**Re: Status of Improvement Permit Application #05-5-13334  
Crestview Lt 180**

CROFTVIEW Lot # 180

05-50013334 Changes needed in house location

Revised
 SITE PLAN APPROVAL
 DISTRICT R300R USE SED
 #BEDROOMS 3
~~12/8/05~~ 12/14/05
 Date
[Signature]
 Zoning Administrator

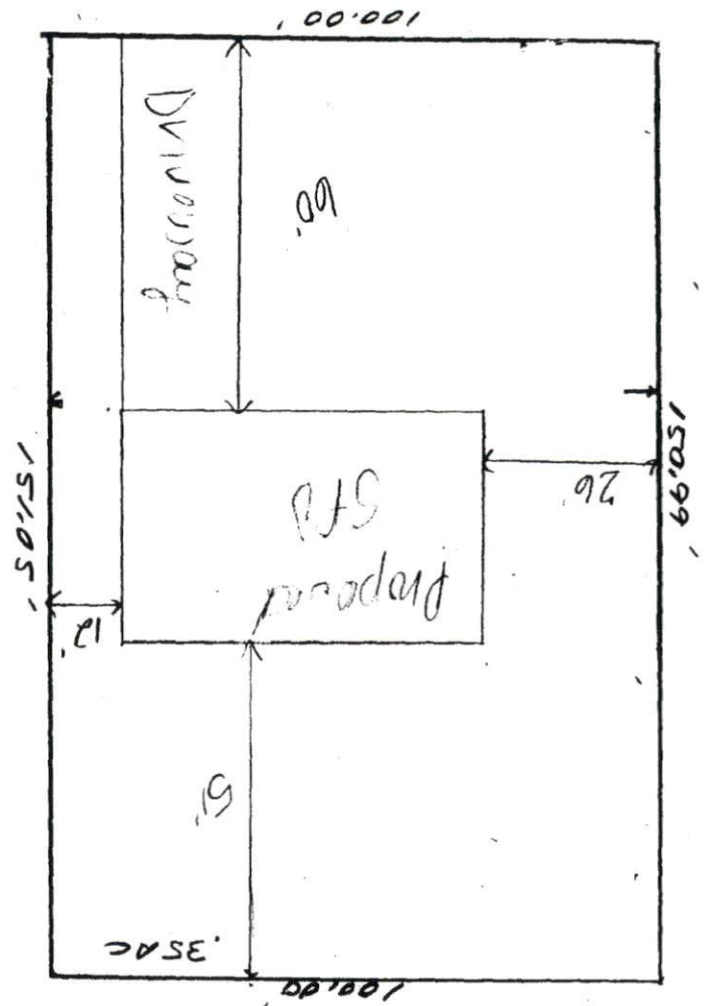
- 1. Property lines/corners not marked or labeled
- 2. House corners not marked or labeled
- 3. Directions not clear to property
- 4. Property needs brush or vegetation removed
- 5. Backhoe pits required
- 6. Other **Make changes to house location as shown. Submit new plot plan to Central Permitting.**
